Our ref: DOC26/228448-6

EPA Advice on Modification 6 – Baiada Oakburn Poultry Processing Facility – Wastewater Treatment Plant Changes (SSD-9394-Mod-6)

Figure 6: Proposed WWTP Layout – Stage 3 (Concept Design)

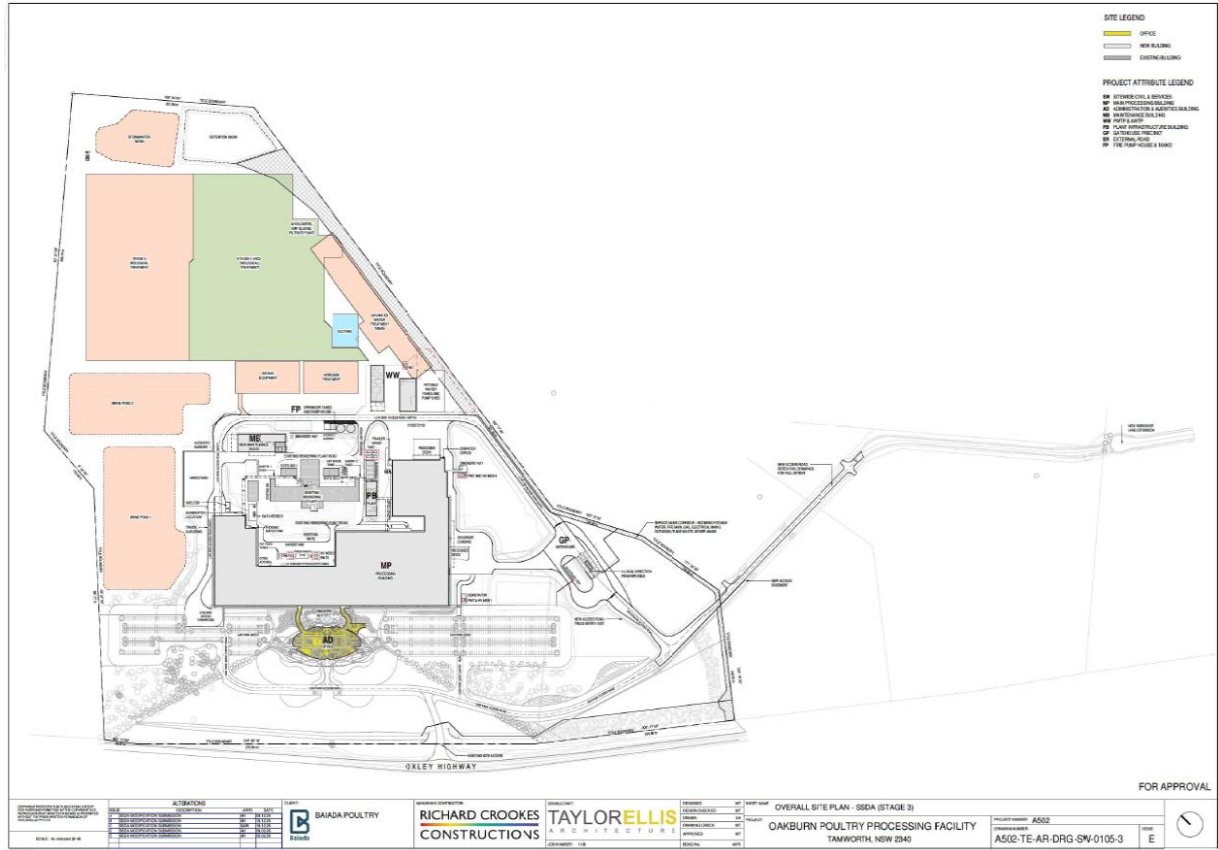
For Stage 3, the concept the Advanced Water Treatment Plant produces a concentrated brine stream which is stored in the Evaporation Lagoons. The Lagoons are fitted with a mechanical water evaporation system that pumps and atomizes water into fine droplets, forcing droplets into the atmosphere to evaporate more quickly. Concentrated brine from Evaporation Lagoons is pumped to a brine evaporation plant that boils the brine under vacuum conditions. The plant then uses an air-cooled condenser to cool the resulting condensate which is then recovered for reuse. Once the desired crystal concentration is reached the slurry is withdrawn from the system for transport offsite for disposal. At full development approximated 150 Tonnes of salt concentrate will be produced per week.

Recommendation: The EPA advises DPHI due to various options available for Stage 3, it is recommended that the modified SSD Consent will need to allow for the submission of a detailed design report to DPHI for approval, prior to commencement of Stage 3.
